Re: Eraring Power Station Ash Dam Expansion MOD 1 (PA 07_0084)

Centennial Coal (Centennial) has reviewed the Environmental Assessment for the Eraring Ash Dam Augmentation Project and, although Centennial does not object to the proposed project, provides the following comments for consideration.

Awaba Workings and Mine Subsidence

Figure 4 | Location of Inactive Mine Workings Below Ash Placement Area

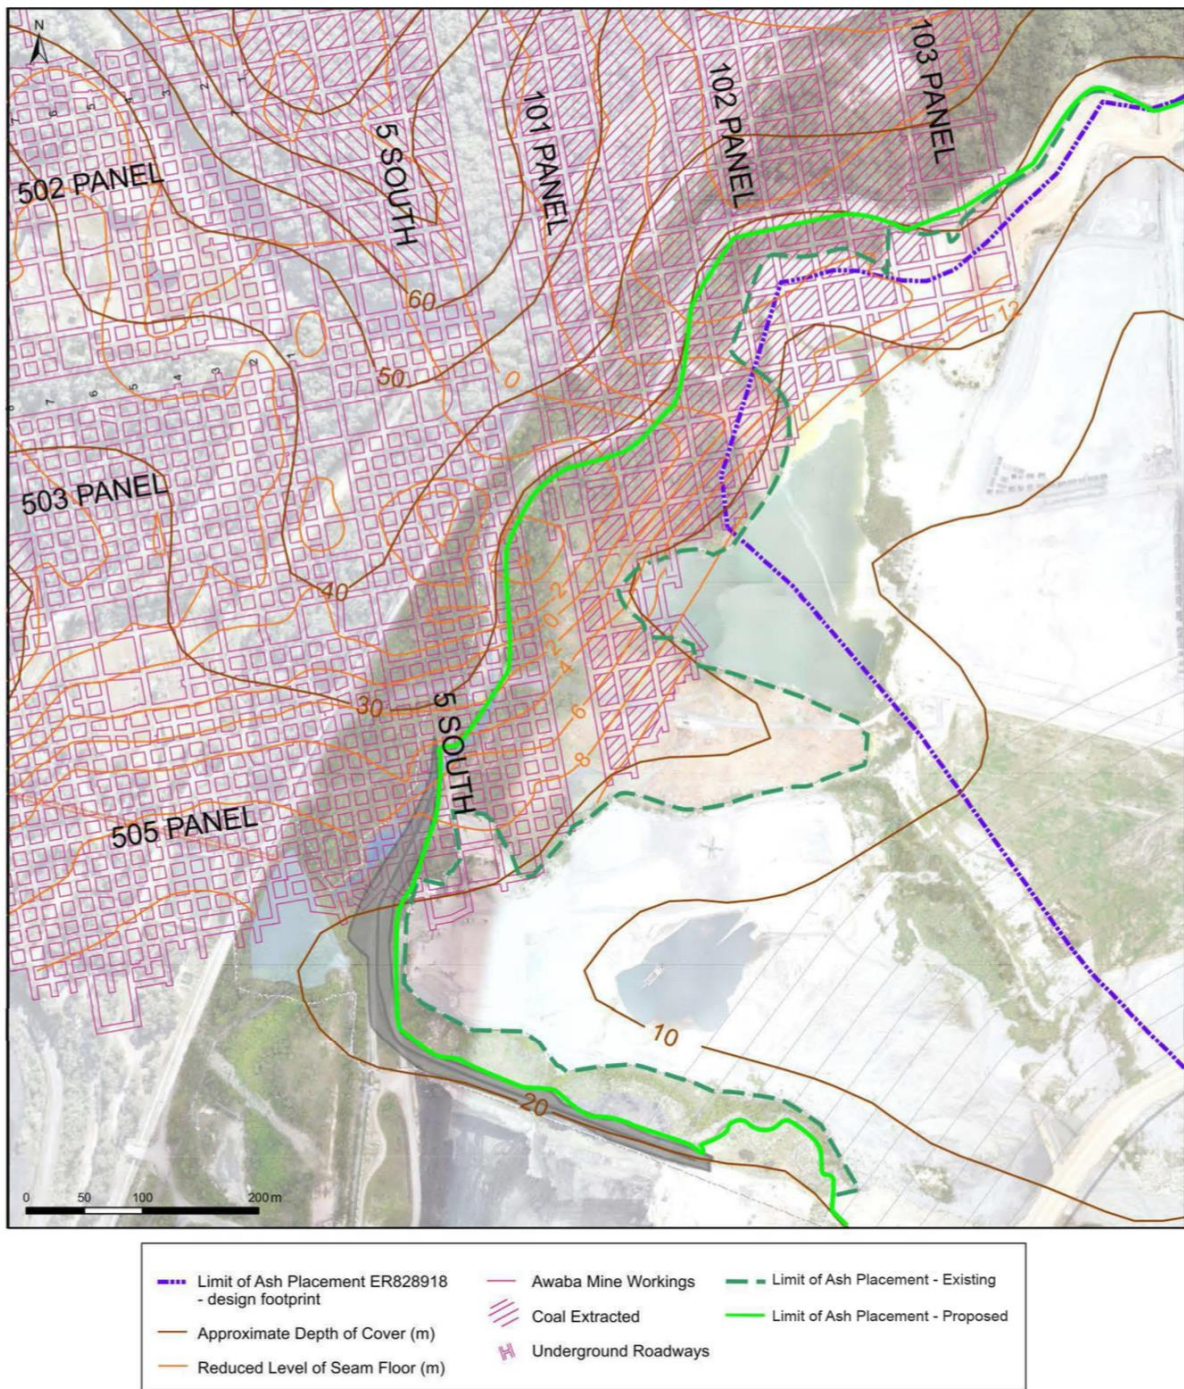
As is identified in the Environmental Assessment, disused mine workings in the Great Northern Seam from the former Awaba Mine lie beneath part of the proposed augmentation area for the Eraring Ash Dam. These workings include areas of full extraction and areas of standing pillars.

Centennial Newstan, a subsidiary of Centennial Coal, currently hold Consolidated Coal Lease 746 (CCL746) over the proposed Eraring Ash Dam augmentation area. Since 2008, Centennial Newstan has been investigating a potential extension of underground mining operations of the Newstan Colliery within CCL746 which includes the area beneath the proposed Origin Energy Ash Dam Augmentation Project. Any future mining by Centennial Newstan would be within the West Borehole Seam, located approximately 200-230metres below the disused workings of the Awaba Mine. When mining beneath the workings of the Awaba Mine, the potential exists for there to be subsidence related interactions within the Awaba Mine workings. These interactions could jeopardise the effectiveness of any mitigation measures implemented by Origin Energy designed to reduce the potential for water connectivity between the Eraring Ash Dam and the Awaba Mine workings.

These mitigation measures and proposed ash containment embankment walls should be designed in consultation with Centennial Newstan and the Mine Subsidence Board to withstand subsidence generated by future extraction in the West Borehole seam to prevent sterilisation of coal reserves.

If grouting of mine voids is selected by Origin as its preferred mitigation technique, any material used to fill the mine voids should be of a benign nature so that it does not adversely impact the quality of the water within the Awaba mine workings.

Figure 12 | Potential offset locations

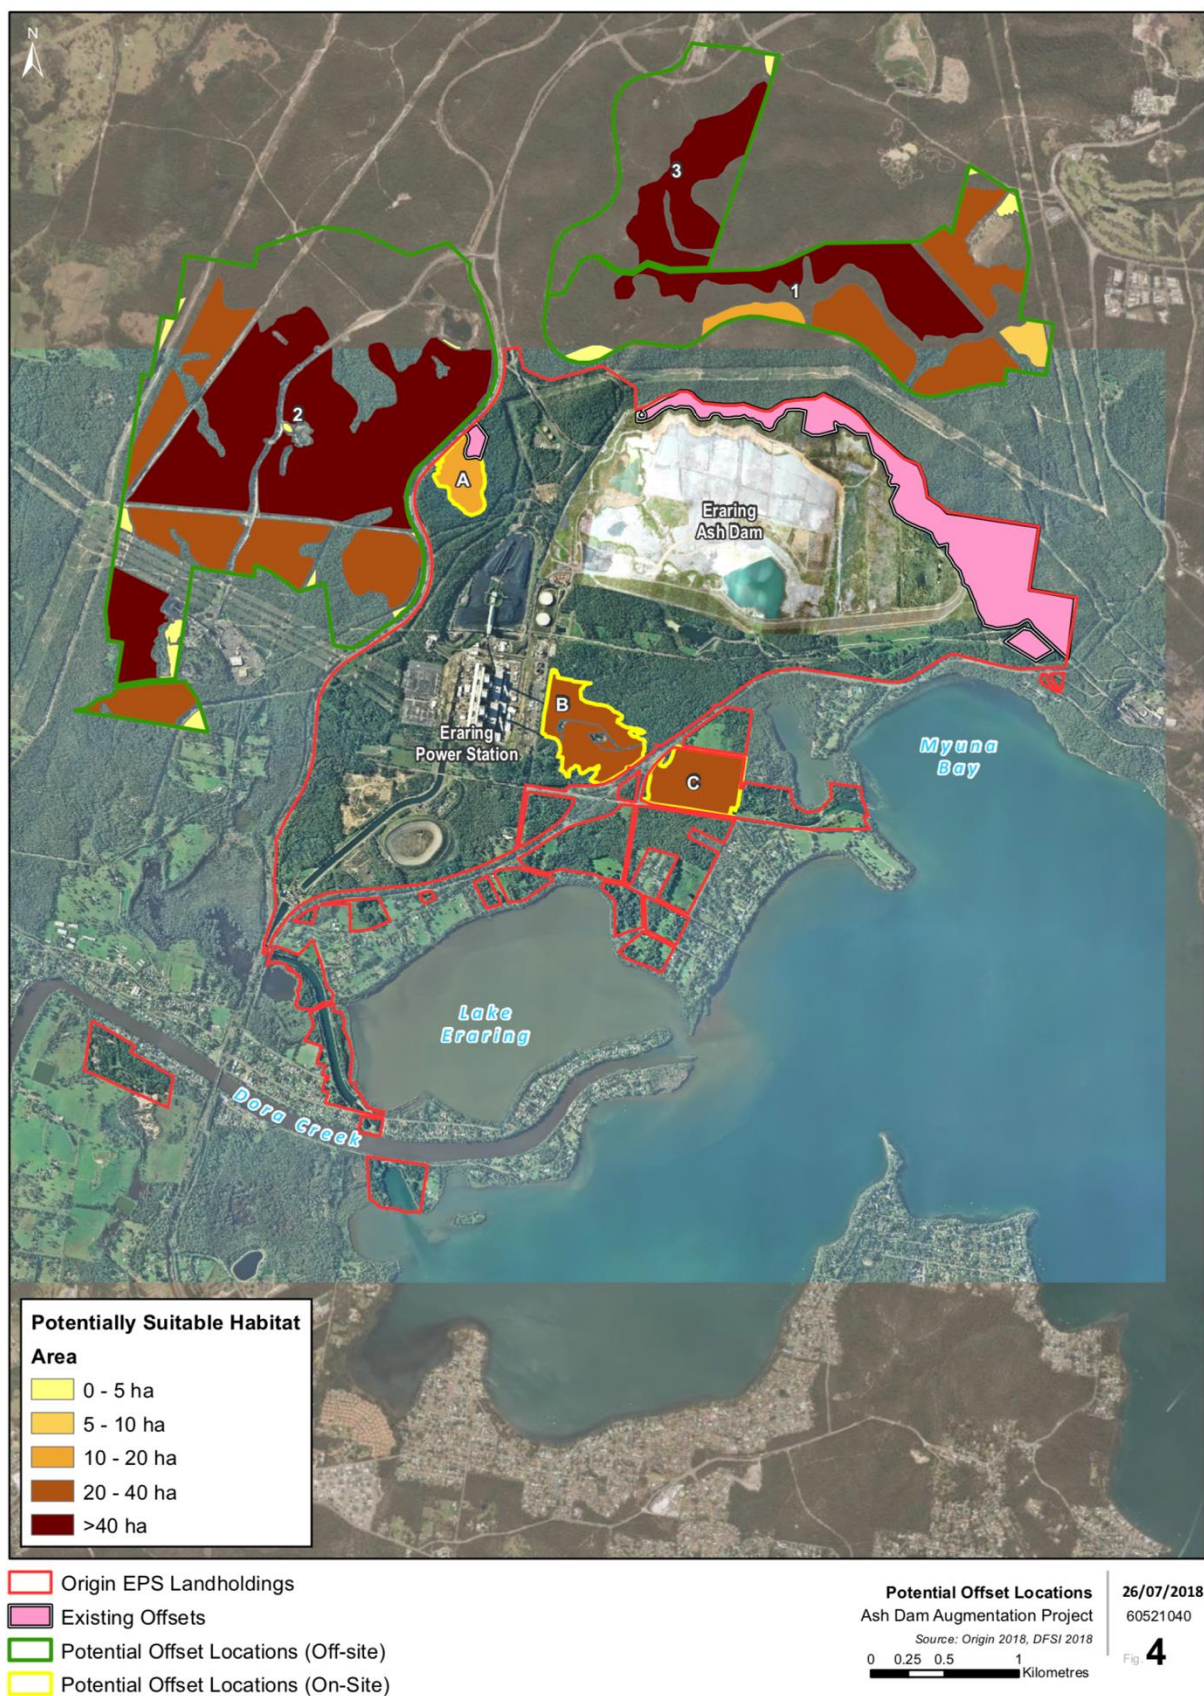
Origin is required to offset the impacts of vegetation clearing associated with the Eraring Ash Dam Augmentation Project. Origin has identified areas of potential offsets on Crown land to the north of the existing Ash Dam. A large portion of these offset areas are within the proposed future Newstan mine extension area where Centennial Newstan holds surface title via mining leases. Underground mining within this area, as well as impacts associated with ongoing subsidence monitoring, has the potential to impact on these vegetation communities. If areas above future proposed mining area are offset, the mining operations and associated monitoring activities could be significantly restricted. Potential offset areas are available outside of the proposed future mine workings and a collaborative approach to identifying areas is proposed that precludes the unnecessary sterilisation of coal reserves. Any offset areas should not be allowed to sterilise coal reserves.
